**From:** Planning  
**Subject:** FW: Lancashire County Council - Public right of Way response to planning app 3/2019/0545  
**Attachments:** 3-2019-0545 Land between Clitheroe Road and A59-A671 roundabout junction Barrow BB7 9AD.pdf

**Reference** 3/2019/0545

**Location** Land between Clitheroe Road and A59/A671 roundabout junction Barrow BB7 9AD

**Footpaths Affected** Fp 6 Ribble Valley Wiswell (3-47-Fp6)

Drawing Title **Plan 1: Landscape Policy and Public Rights of Way**

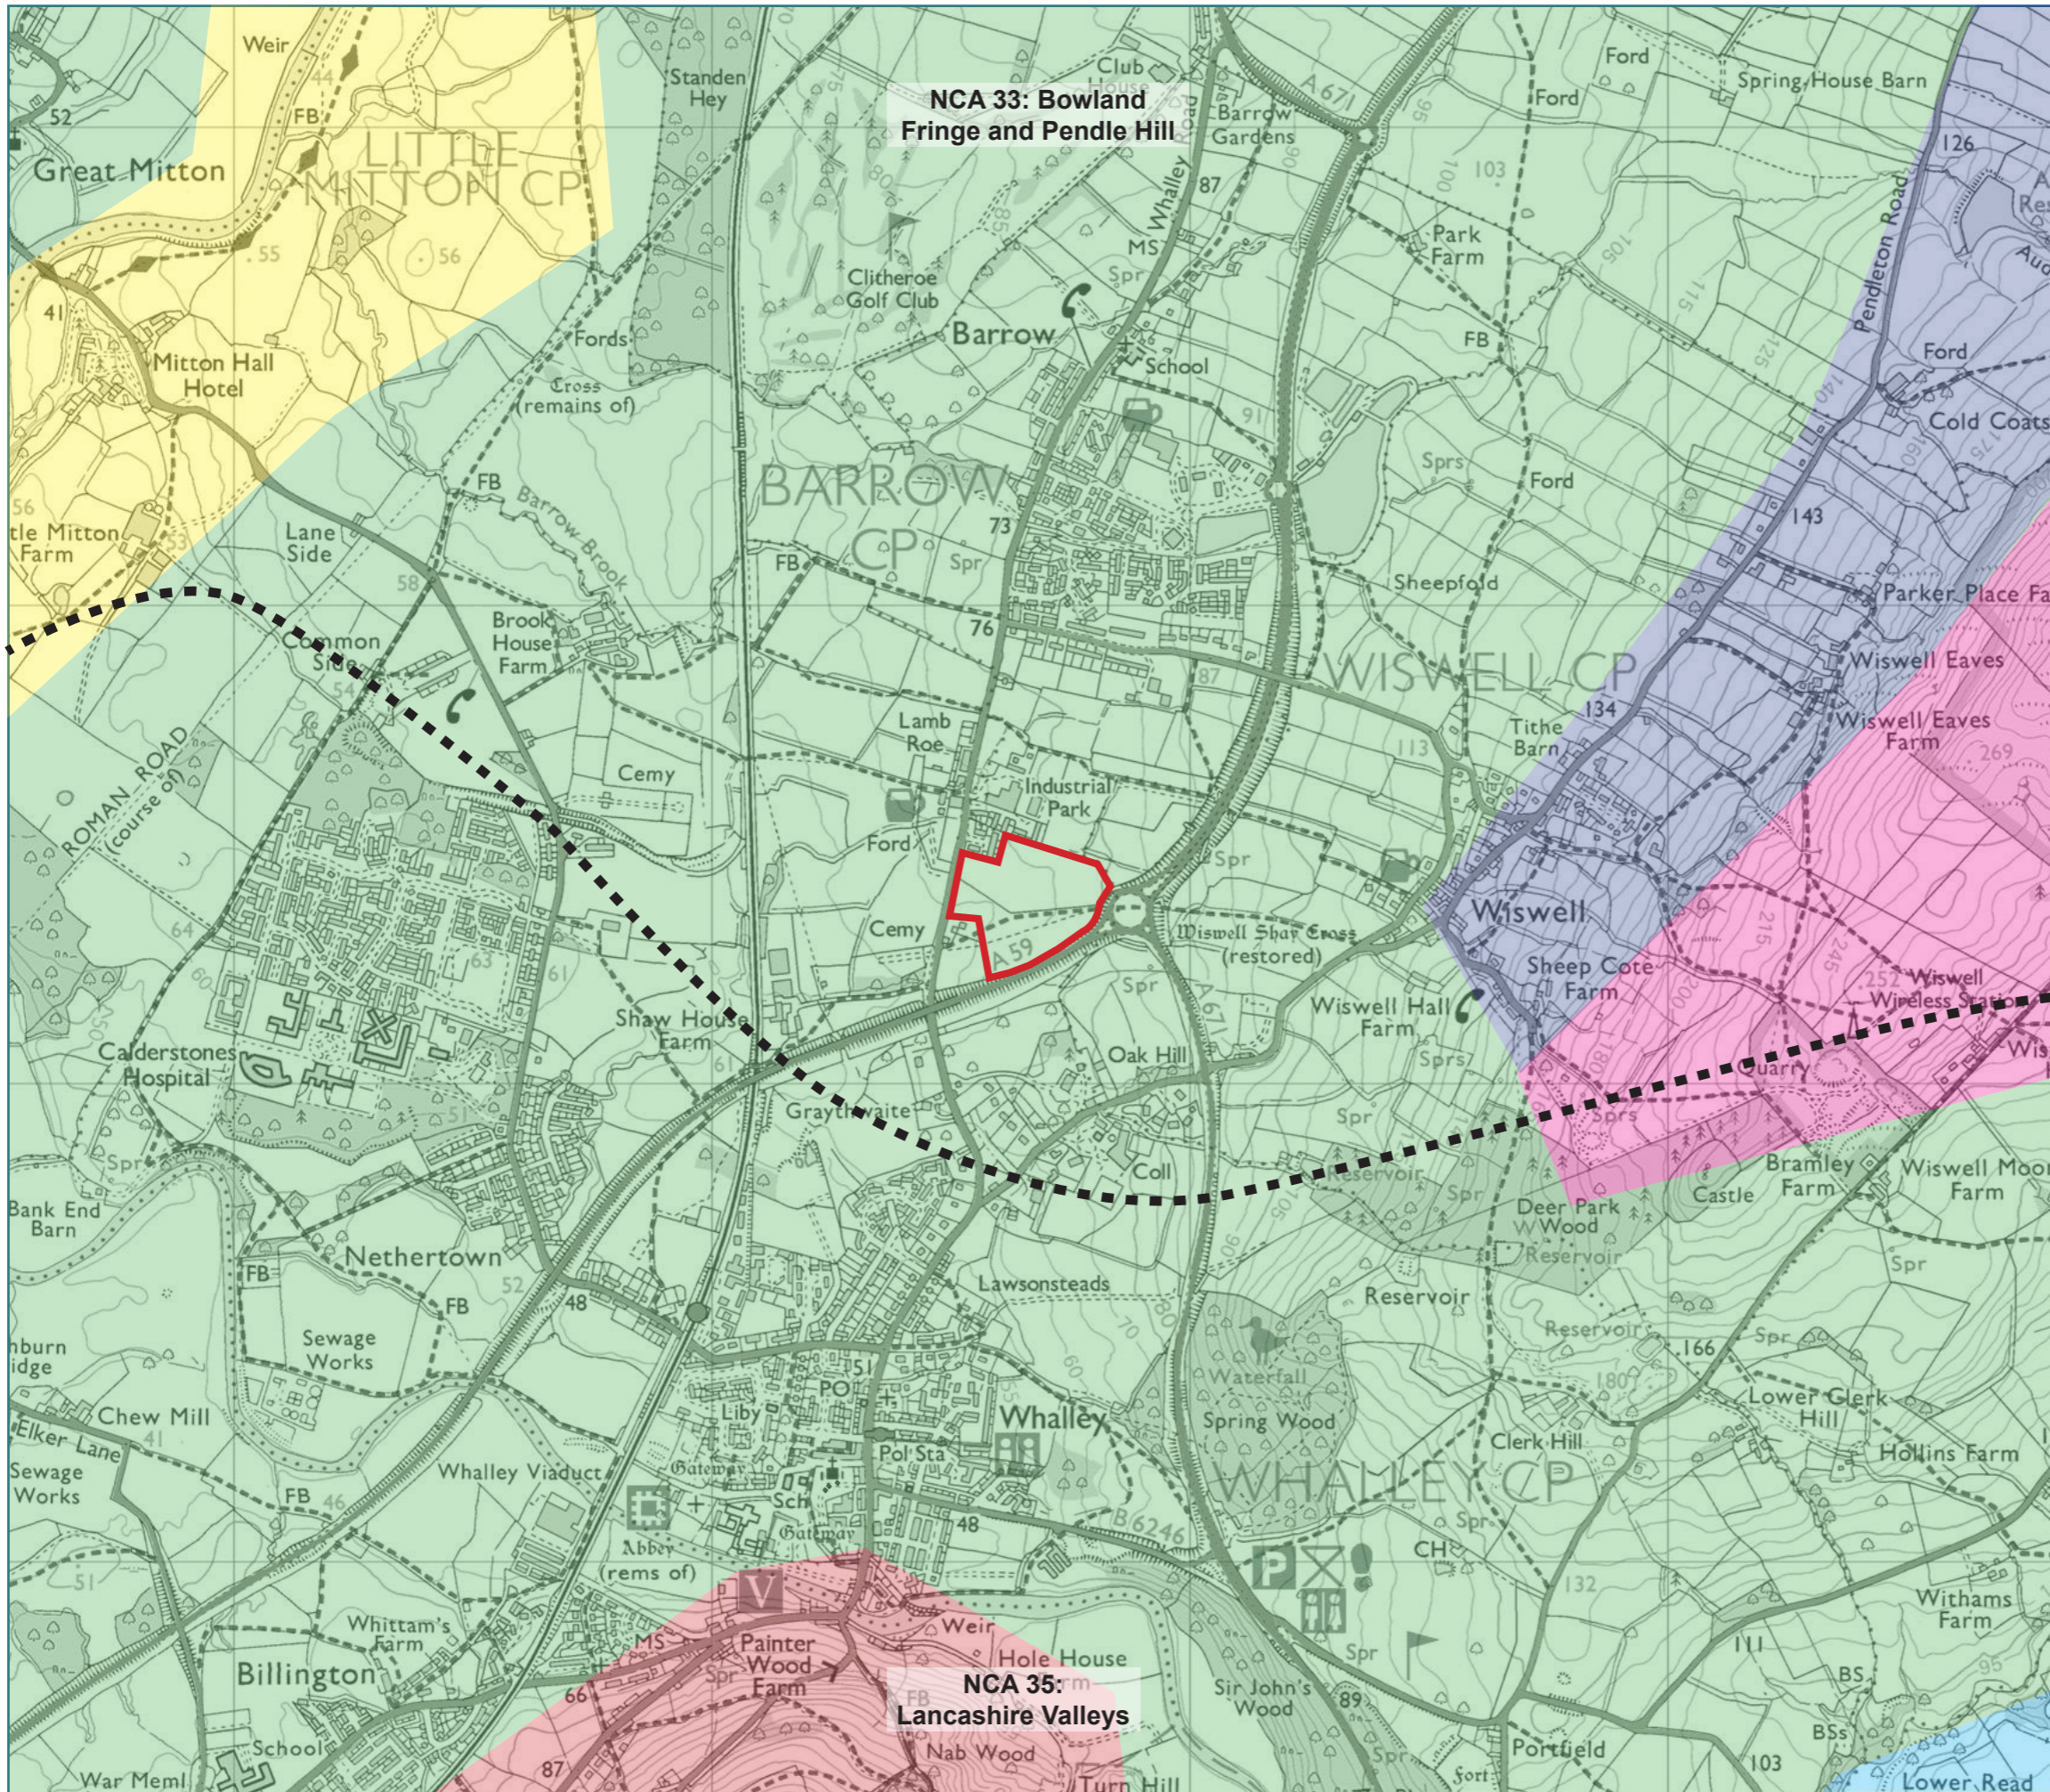
I have identified Public right of Way **3-47-FP6** (see attached overlay) within the proposed development site and feel that the development needs a more comprehensive scheme to improve connectivity to Wiswell – it is proposed that footpath **3-45-FP11** be diverted to the south of the proposed site and the diverted path should link back with the north eastern arm of the A59 at the existing crossing location for pedestrians walking to and from footpath **3-47-FP6**. The diverted path must be a minimum of 2 metres wide with adequate drainage and a bound surface.

- **Public Rights of Way request £30,800 S106 monies** to improve the remaining length of **3-45-FP11** which is outside the proposed development and footpath **3-47-FP6**.

Any landscaping should be at least 3 metres away from a public right of way – overhanging branches/foliage and roots can create health & safety risks to users of the footpath plus long term maintenance issues.

Any alterations in ground level should take into account Public rights of Way to ensure surface water is not channelled towards or onto a footpath – higher level of ground in the vicinity of a footpath can cause flooding issues.
